Planning Application Ref: BN/35/18/DOC

Location: Land at former Pollards Nursery, Lake Lane, Bognor Regis

Description of works: Approval of details reserved by condition imposed under BN/16/12/ relating to conditions 5-surface water drainage, 6-maintenance of SUDs, 7-foul drainage system, 8-schedule of materials & finishes, 10-details of existing trees & shrubs, **11-protection of retrained trees**, 12-provision of public open spaces, 13-details of boundary treatments, 14-landscape management plan, 15-details of low carbon energy sources, 17-ecological enhancement measures, 18-reptile mitigation & translocation plan, Ecological Clerk of Works, 20-noise mitigation measures, 23-layout & specification of & construction program for roads, footpaths, foul & surface water drainage & means of disposal & 25-pedestrian visibility splays.

Condition 11 –

Title Tree Protection Plan (Sheet 1 of 3)

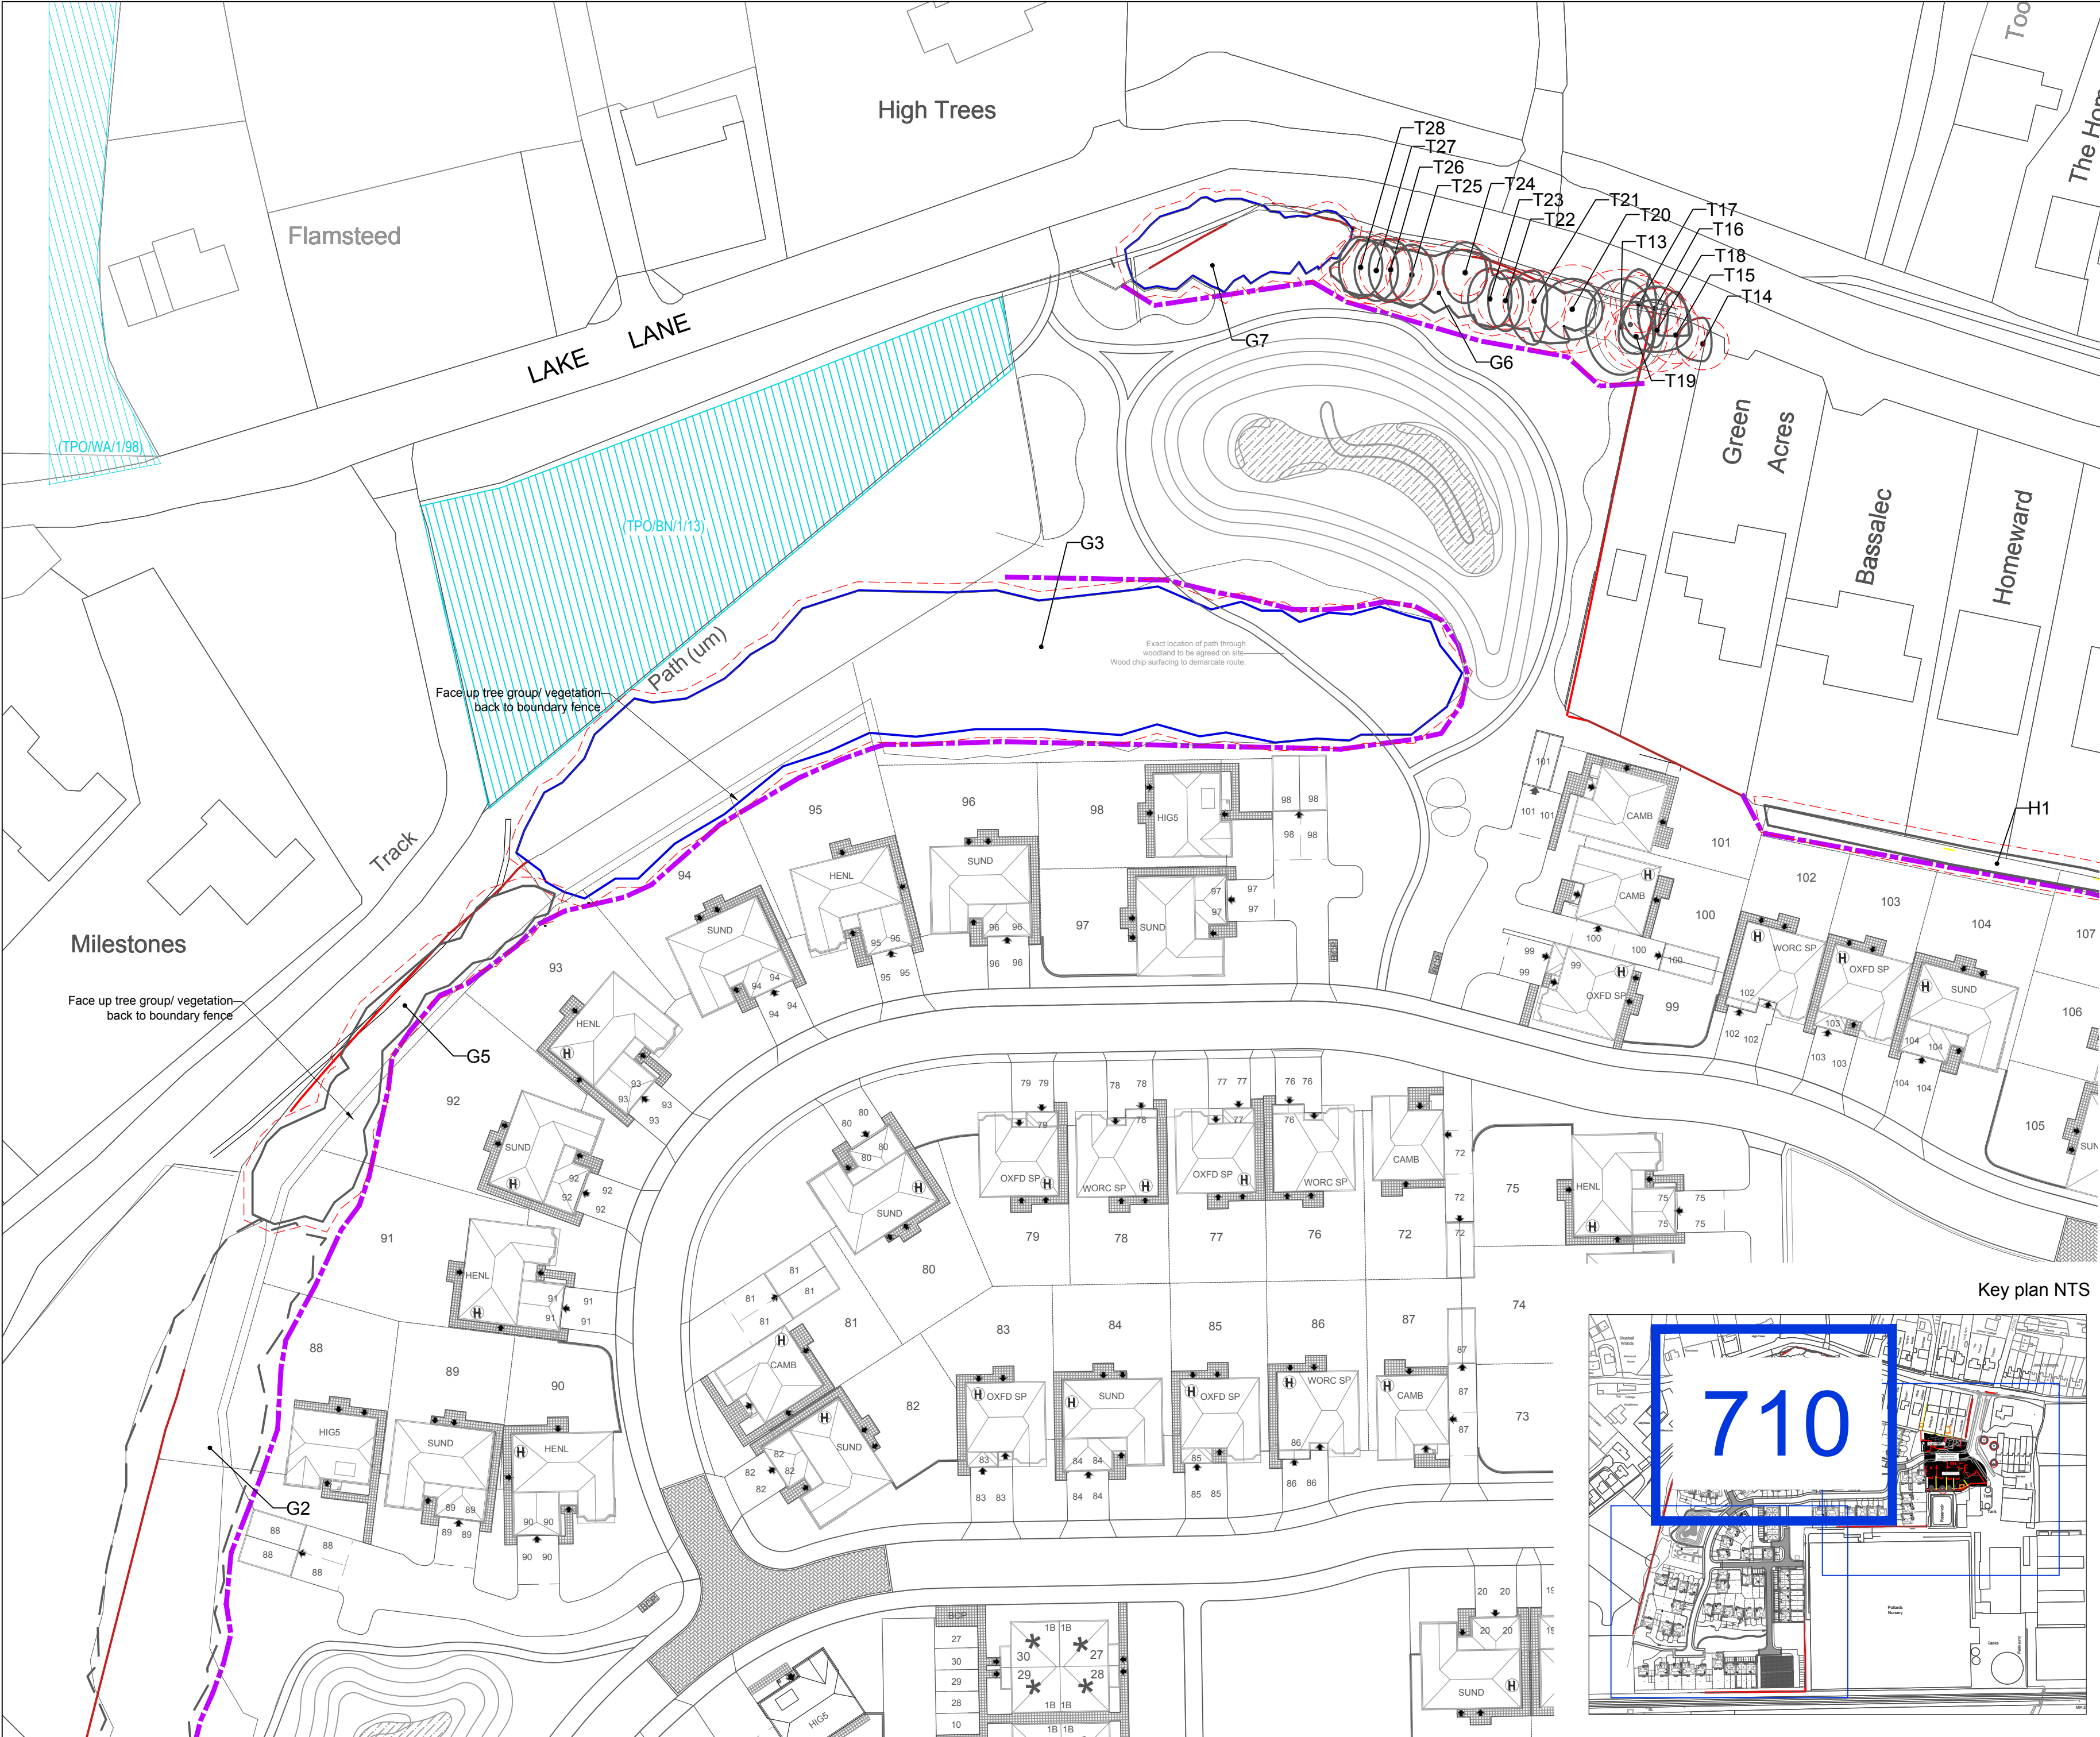
- 710 E (Sheet 1 of 3)
 - 1x panel of HERAS fence damaged and flat on the ground, at NE corner of tree group (G3). Repaired and reinstated 23rd August 2018 (pm).

- 1x panel of HERAS fence removed during recent site break-in, somewhere to rear of plots 94-96. Police informed of property stolen from secure container. Repaired and reinstated 23rd August 2018 (pm).
